31 May 2013

## **CHAFFEY DAM AUGMENTATION AND SAFETY UPGRADE PROJECT (SSI 5039)**

This letter has been prepared to respond to Commonwealth and State Government Agencies' comments on the Preferred Infrastructure Report (PIR) for the abovementioned project. The letter is accompanied by:

Figure 4-1: Proposed raising of the dam wall

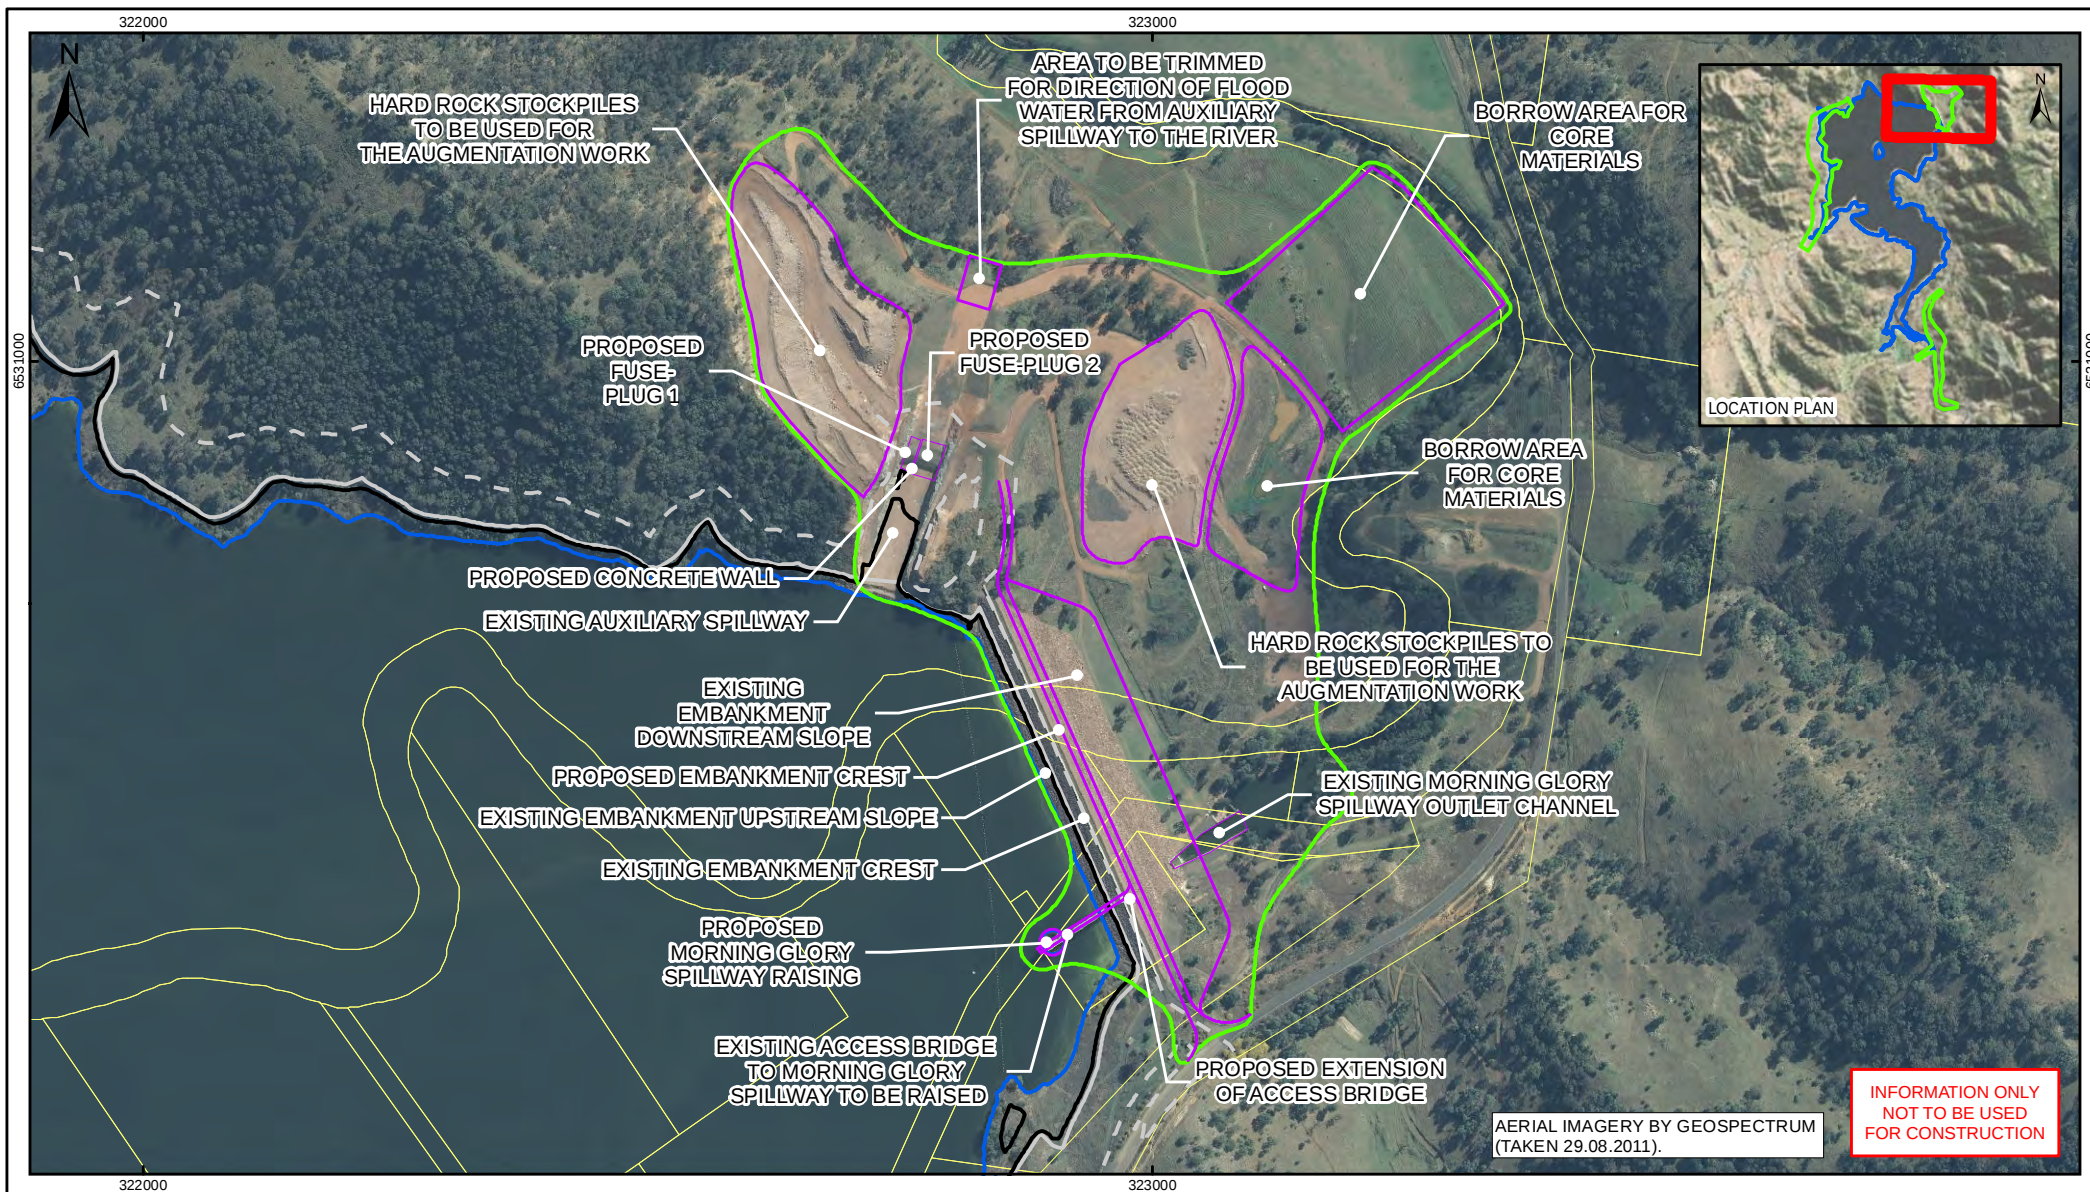
The dam wall construction method is also proposed to be modified. The dam wall raising will now be achieved by the construction of a vertical reinforced earth wall that is to be constructed on the crest of the existing dam wall. The construction of the reinforced earth wall will not require any excavation of the dam wall toe or any placement of rocks on the downstream embankment. The wall raising and access will be limited to the crest of the dam wall.

In addition, the revised construction approach will mean that there is no longer any requirement to raise the morning glory spillway access bridge and piered platform.

A cross-section of the revised design for the dam wall raising, showing the existing and new crest elevations, is presented in **Figure 3**.

DATE : 28 Aug 2012
CUSTOMER : STATE WATER
REF : 301015-02980-GIS-SKT-005.mxd
REV : A1

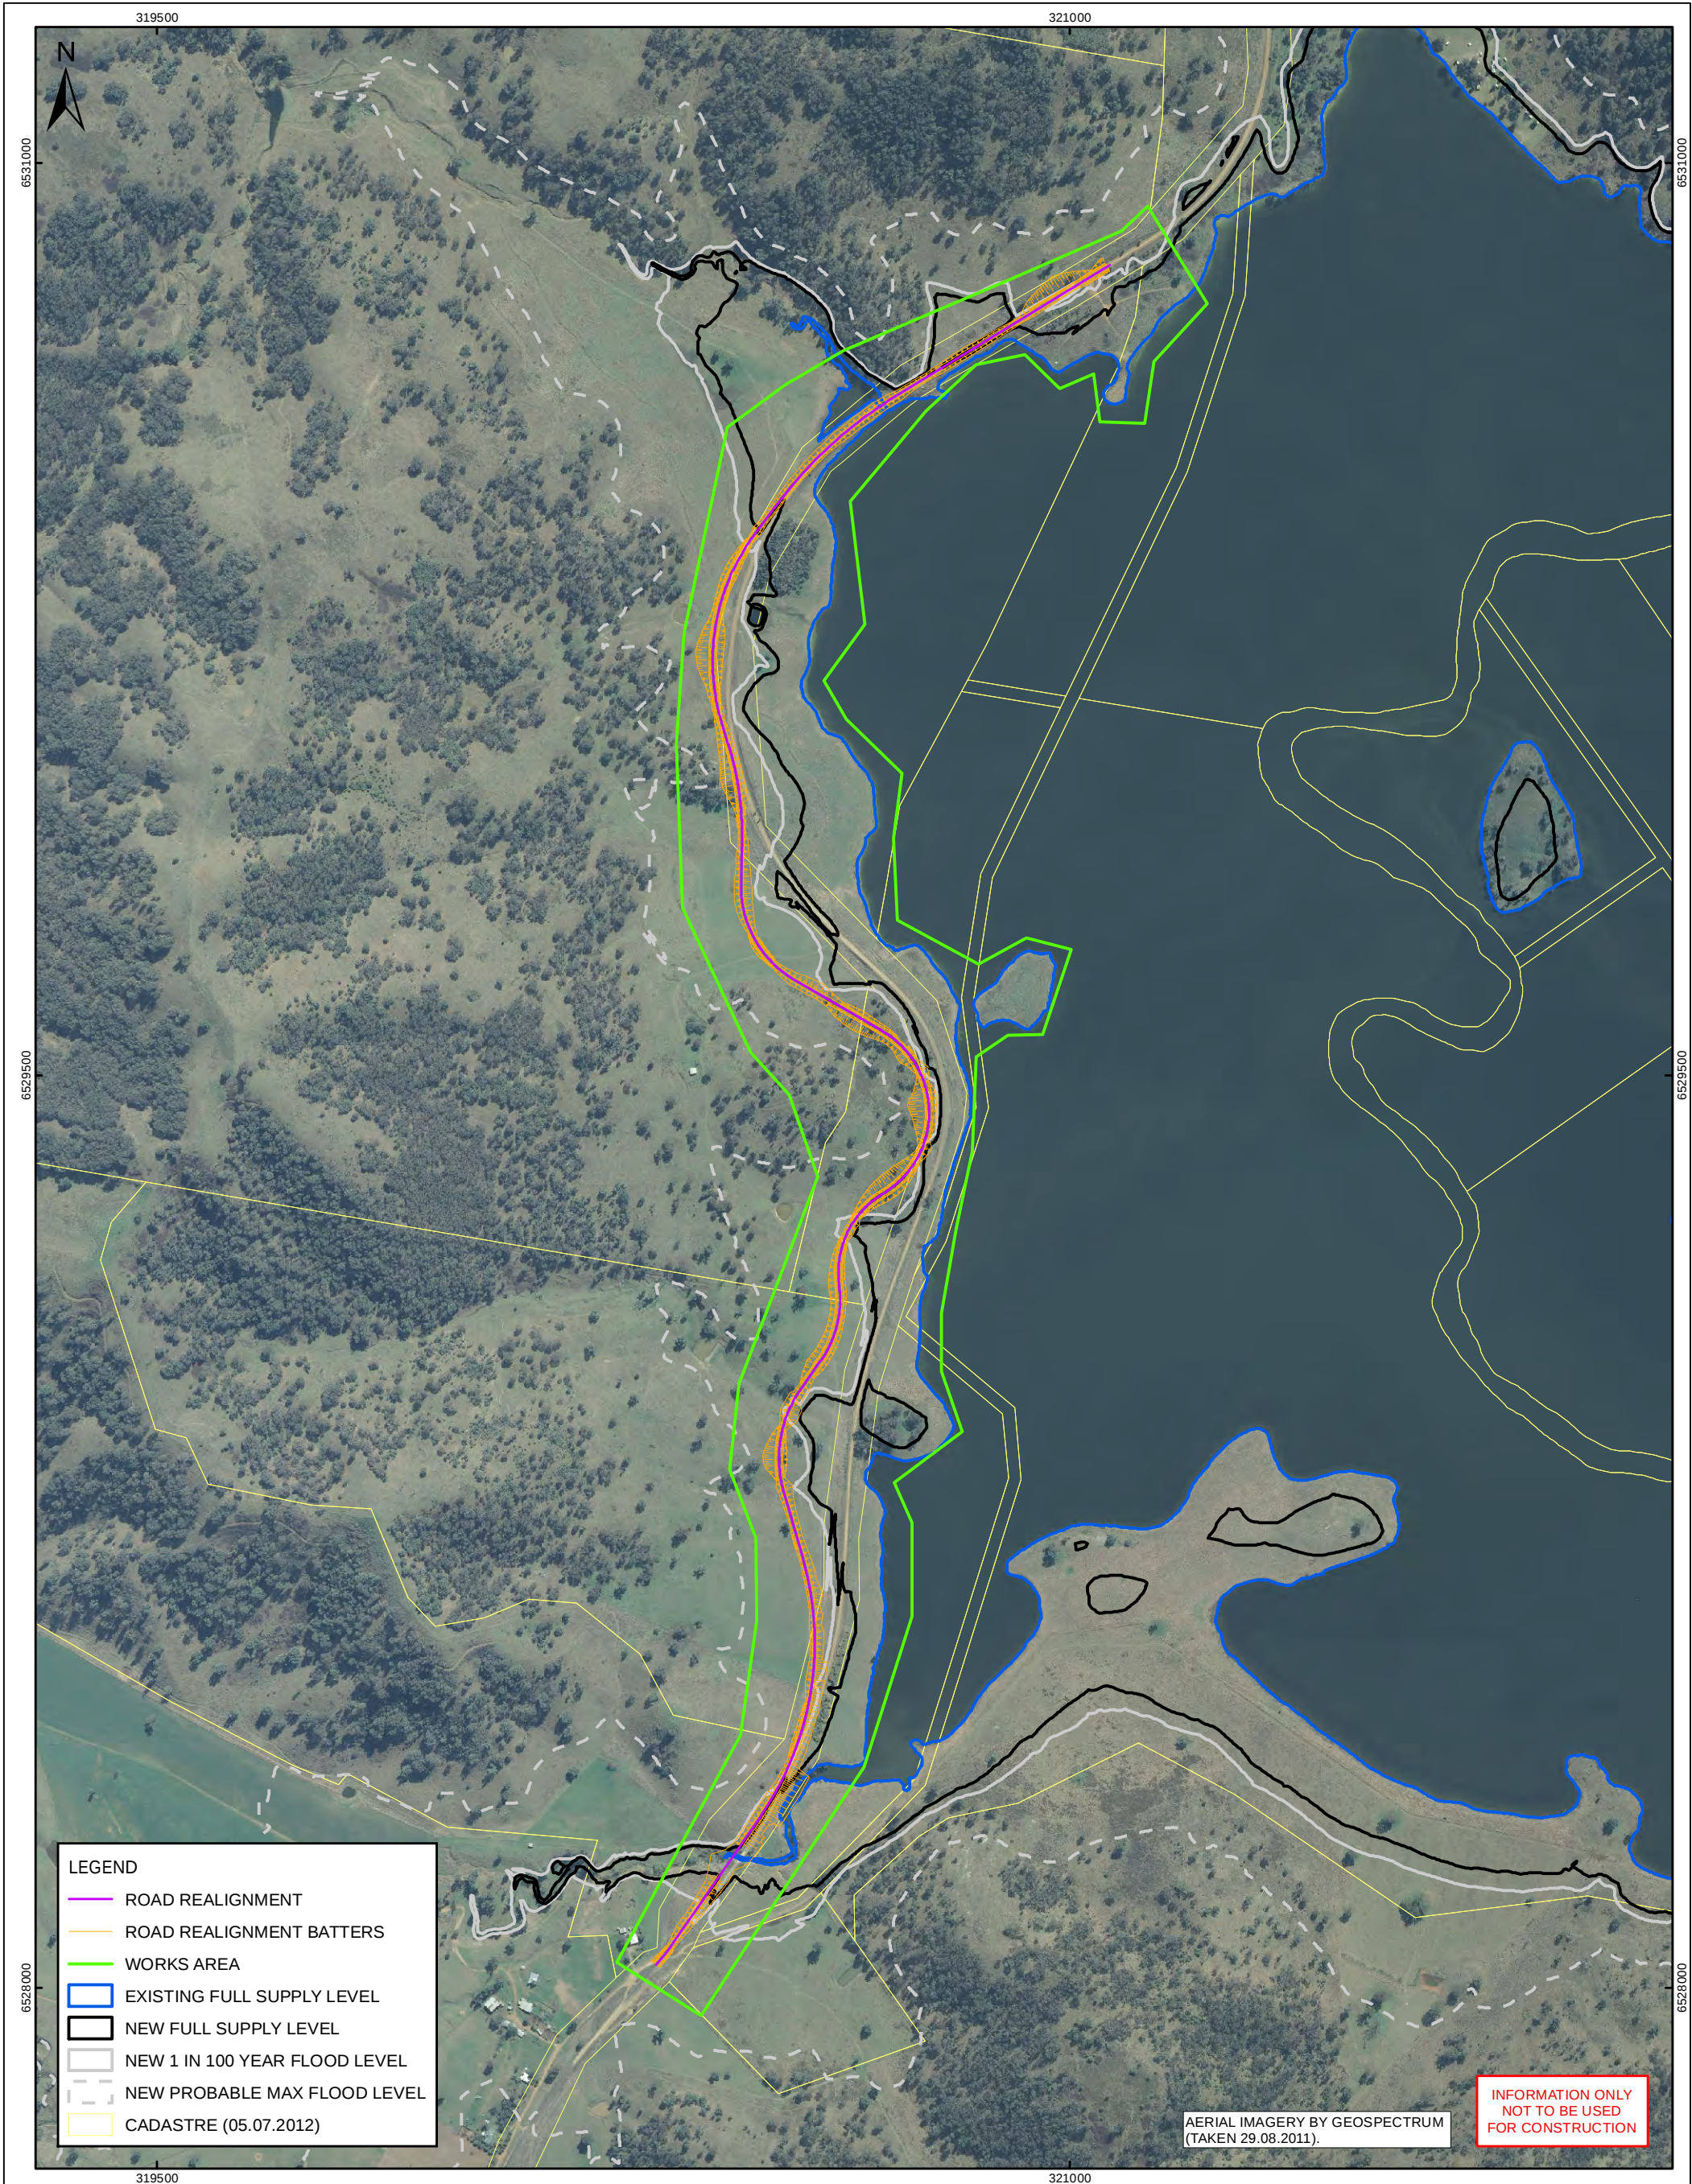
The southern extent of the dam wall works area, as presented in the Project Environmental Impact Statement (EIS) and PIR, is proposed to be increased in size by 1.5 ha which would increase the overall works area from 33.6 ha to 35.1 ha. The additional area is currently occupied by cleared land and exotic vegetation. No environmental impacts additional to those assessed in the EIS and PIR are anticipated to occur.

The revised dam wall works area is shown in **Figure 1**. The Project Layout, incorporating the revised dam wall works area, is shown in **Figure 2**.
